Auburn Community Hub (MP_0173)

Agency and Issue	Response
RTA	
1. The proposal includes a reduction in the number of on site parking spaces from 228 to 184 car spaces. The reduction of on site parking spaces can promote use of public transport however this may also compel visitors and employees of the hospital to seek parking on nearby local roads.	<p>While there is reduction in spaces for Stage 1 the parking provision of 184 complies with Condition B11 of the Project Approval for the hospital and is consistent with the transport objectives for the site. The new Work Place Travel Plan that is being prepared in conjunction with the Auburn Hospital focuses on decreasing demand for individual car use among employees and improving car sharing/pooling as highlighted in the survey conducted as part of the Concept Plan. To further encourage decreased car use, eight (8) dedicated car spaces have been provided for the exclusive use by vehicles used to car share. In addition a travel smart plan is being development across both the hospital and hub to encourage use of the existing public transport.</p> <p>Action: Additional Statements of Commitment (SOC) have been added.</p>

Drawing Title: SITE PLAN

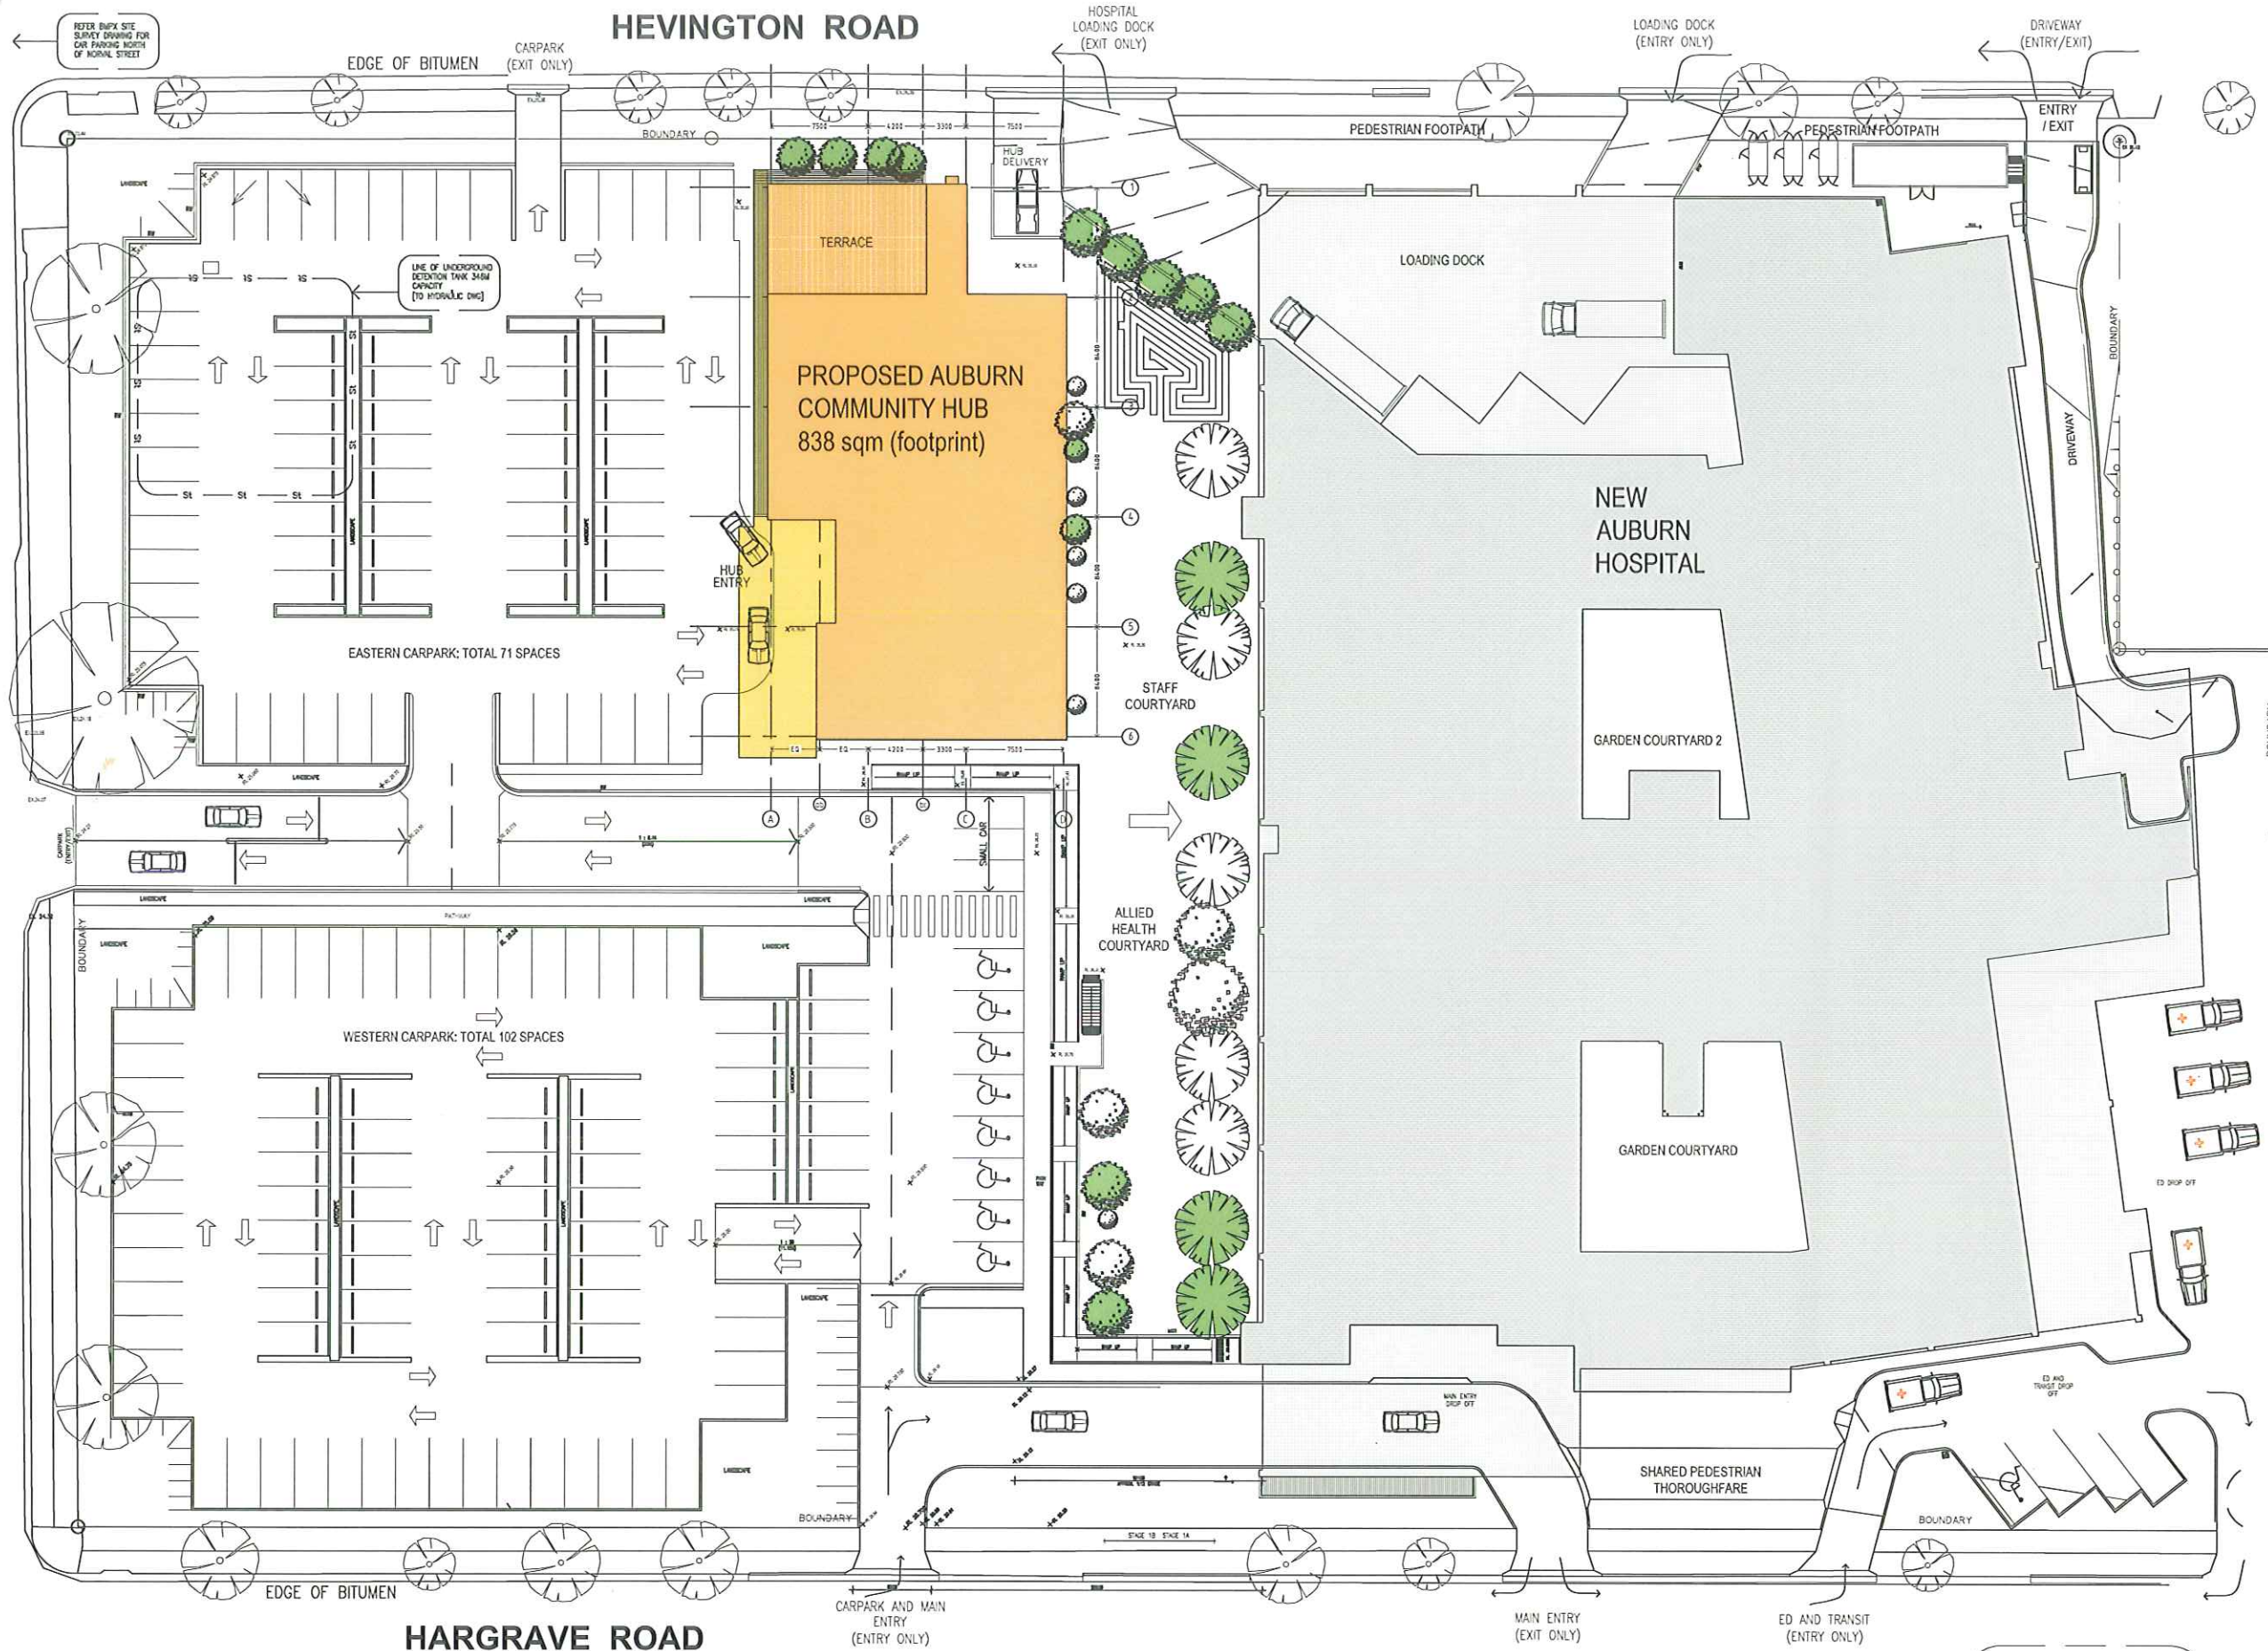
14. Notes that the development will result in a loss of 44 approved car spaces and while the NSWTI supports reduced parking provision, the implications for public transport, pedestrians and cycling also need to be addressed.	Noted. The traffic report prepared as part of the Concept Plan approval and reviewed for this application has determined that there is sufficient capacity within the public transport network to cope with increased demand on its use. The improvements to the Integrated Network Plan for Bus Contract Region 13 will also facilitate improved access and greater encouragement to use non car
